October 27, 2025

**Re: Albuquerque School of Excellence at 5310 Sequoia Rd NW
Erosion and Sediment Control Plan
Engineer's Stamp Date – 8/22/25 - G11E048 (SWQ-2025-00041)**

James D. Hughes, P.E., CPESC
Principal Engineer, Planning Dept.
Development and Review Services

EROSION CONTROL PLAN

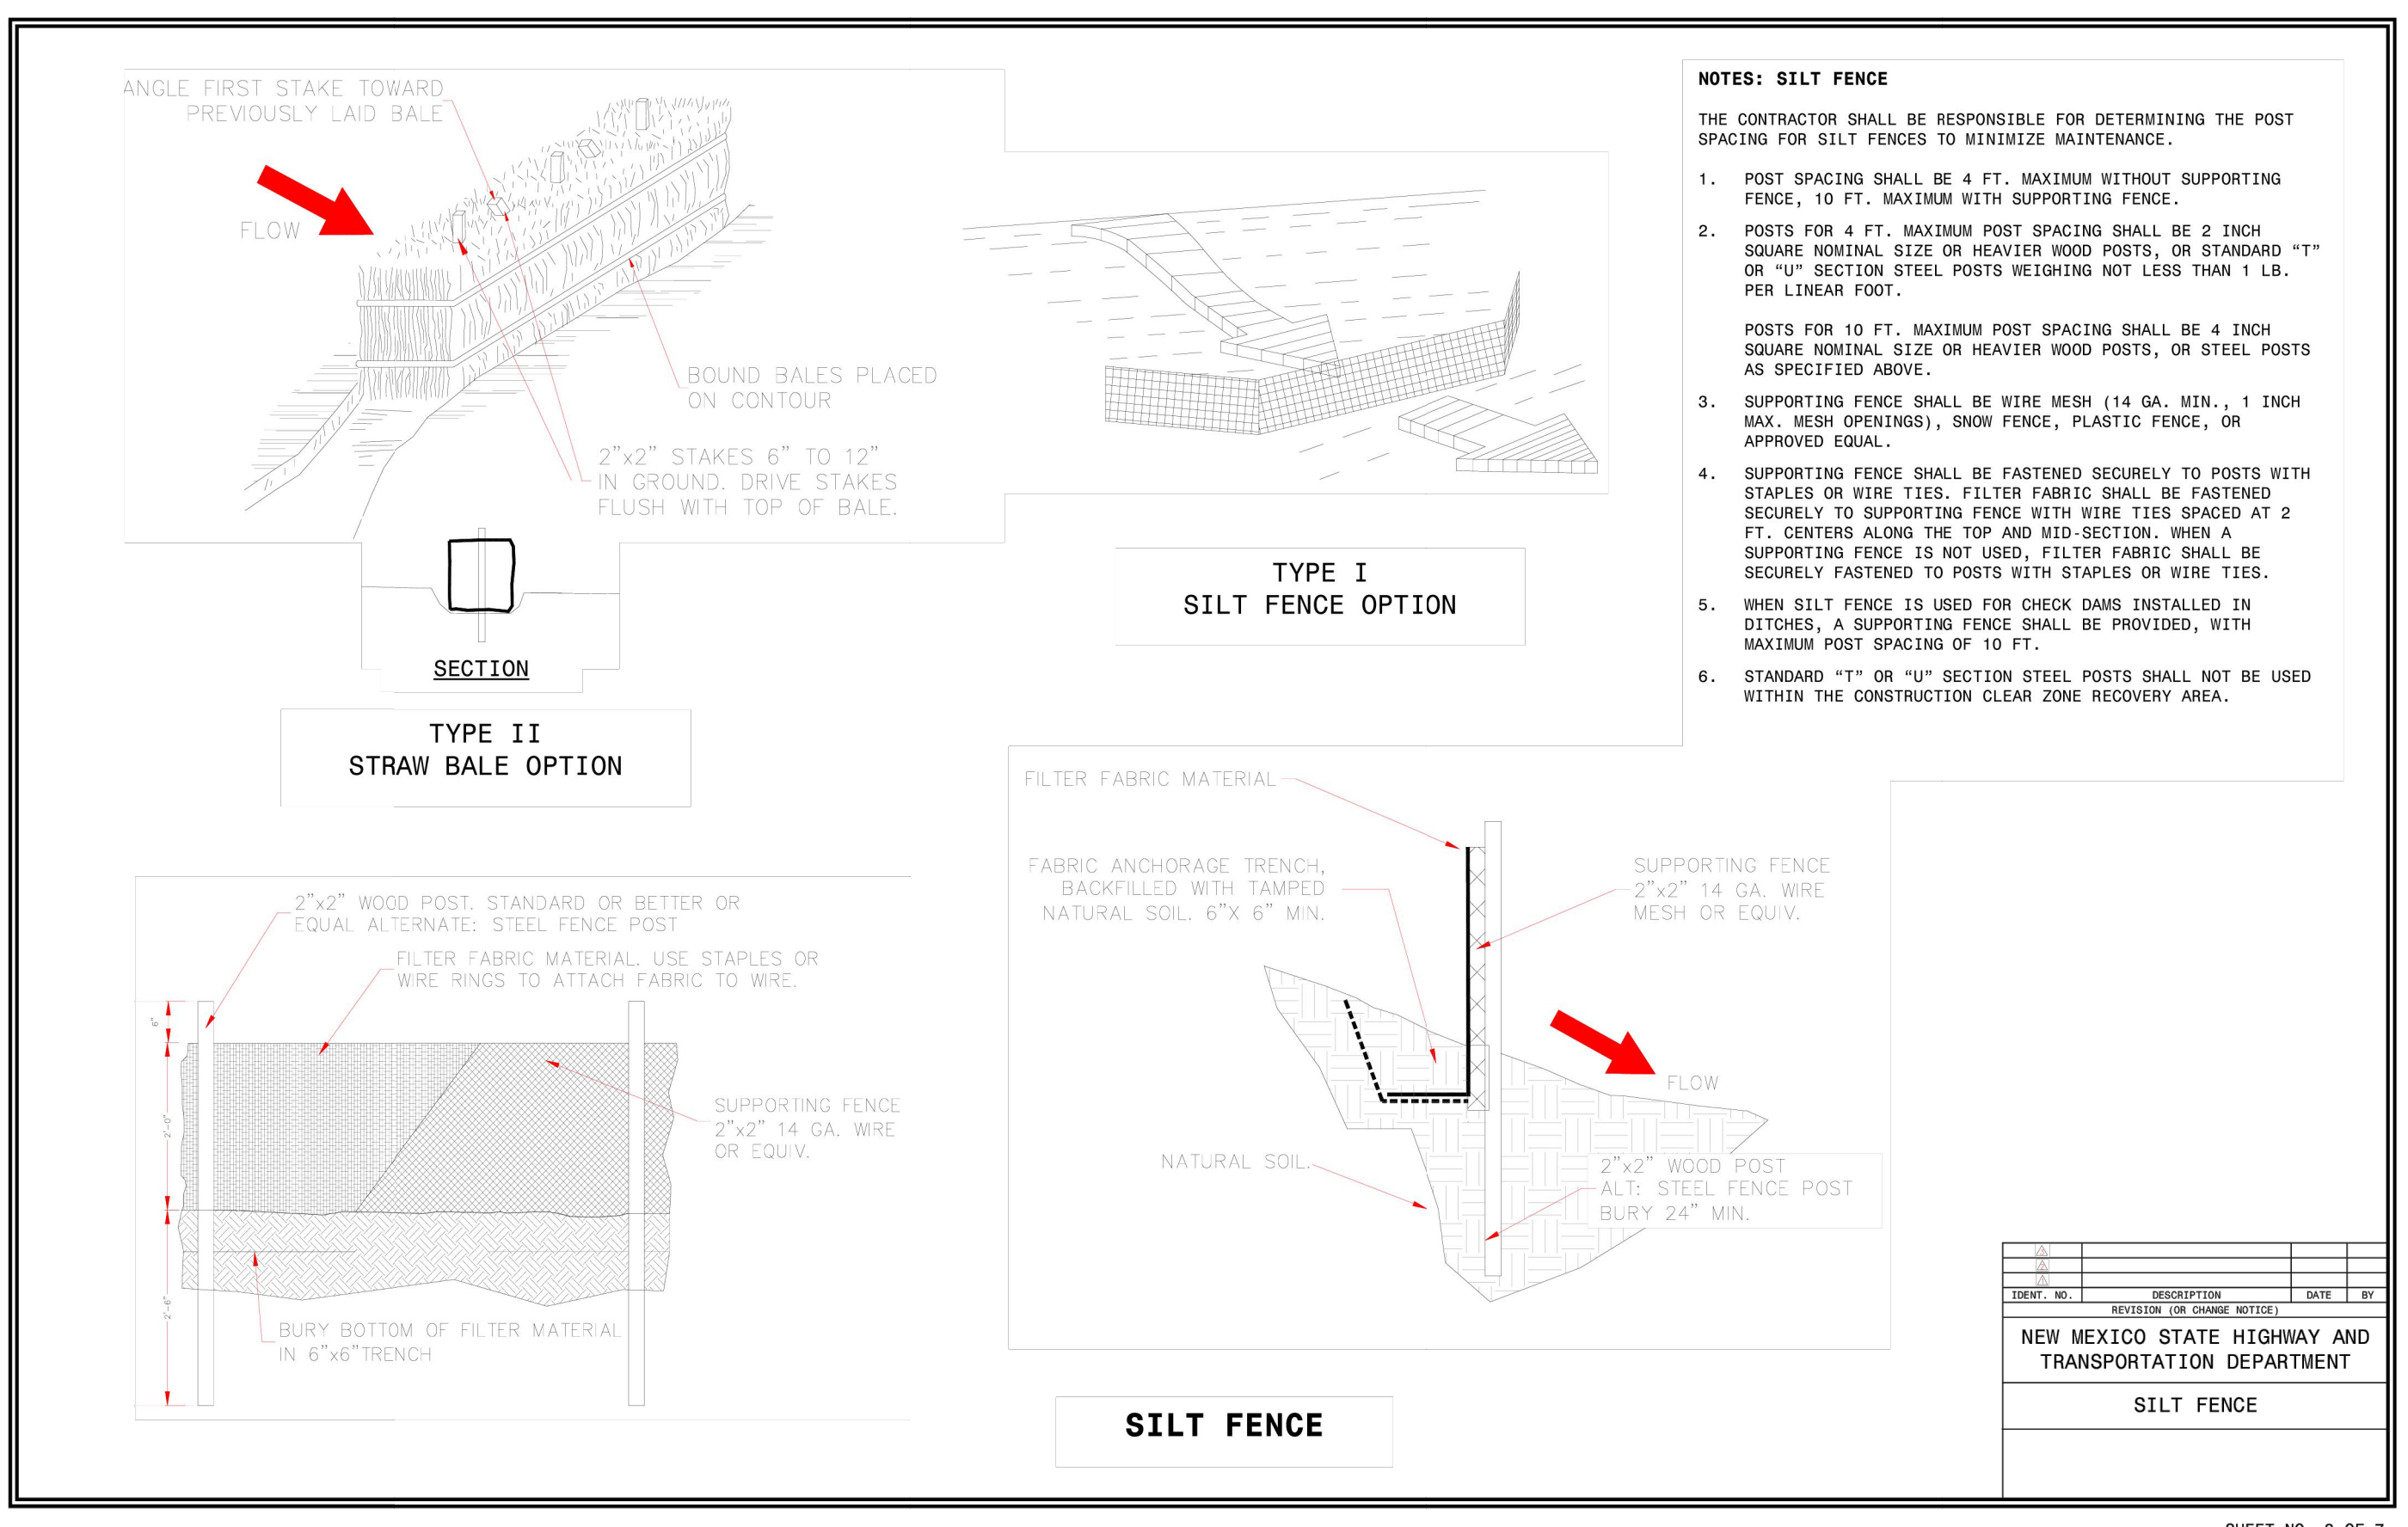
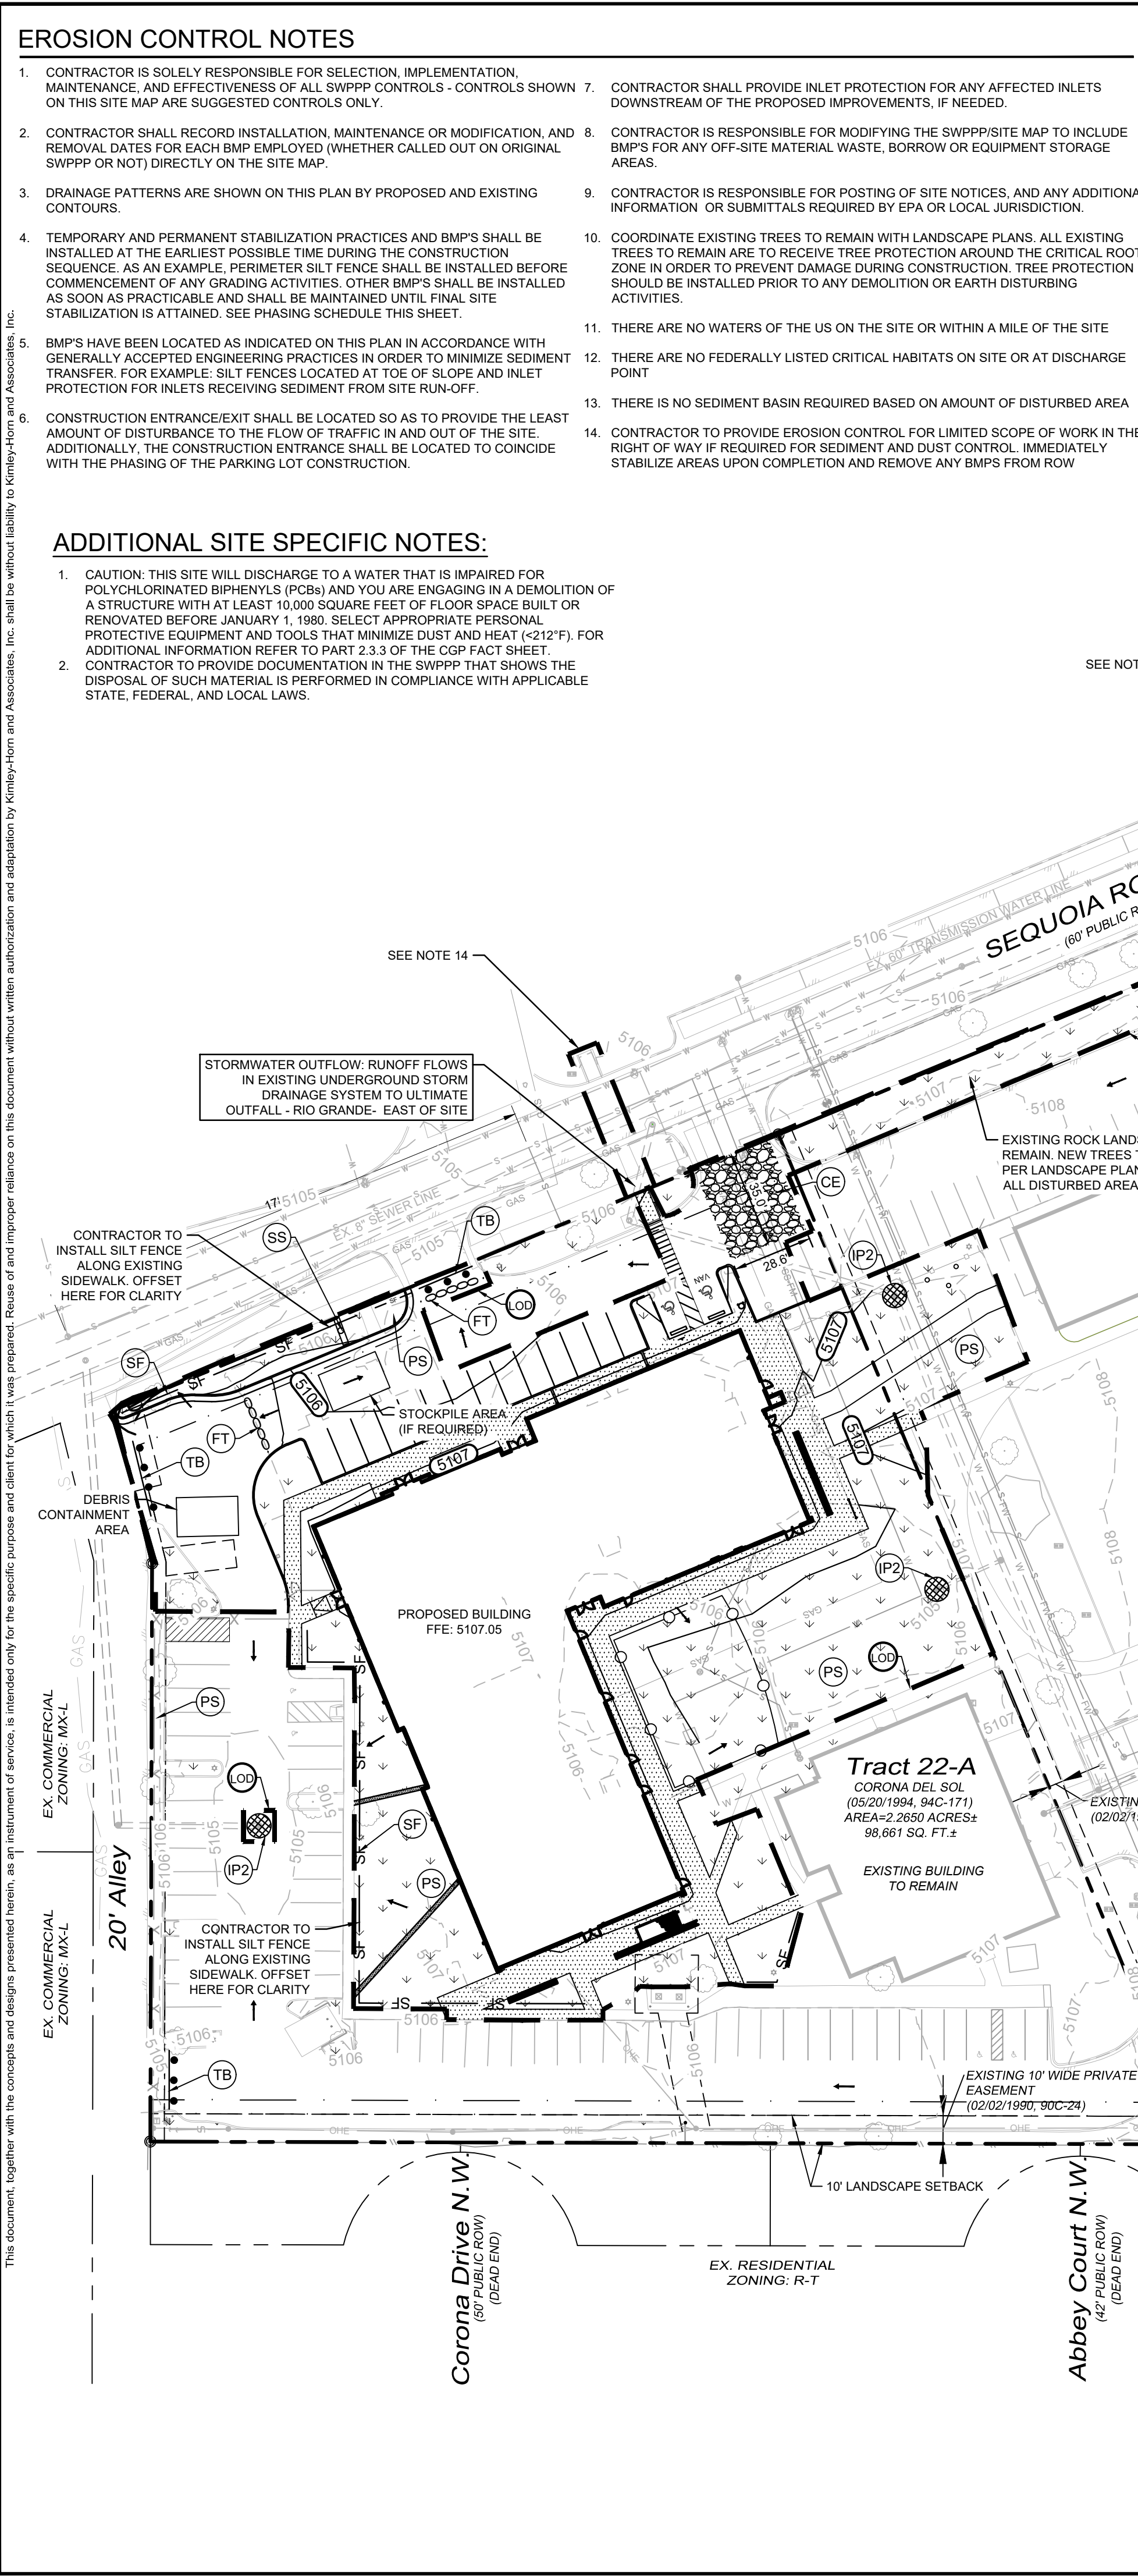
2. This project's scope includes demolition of a building larger than 10,000 sf. built before 1980. You must correct the NOI and identify controls on the ESC Plan to minimize the exposure of PCB-containing building materials to precipitation and stormwater. Specify covers for all waste, including PCB-containing demolition debris, during precipitation and non-work hours per CGP 2.3.3.e.

3. Note #11 of the Additional Site-Specific Notes says "*there are no waters of the us on the site or within a mile of the site,*" when they are less than a half mile from the site. The note must be corrected and *identify if any of these receiving waters are listed as impaired,* per CGP 7.2.4. The ESC Plan must also show the *Locations of all receiving waters within one mile downstream of the site's discharge point(s).*
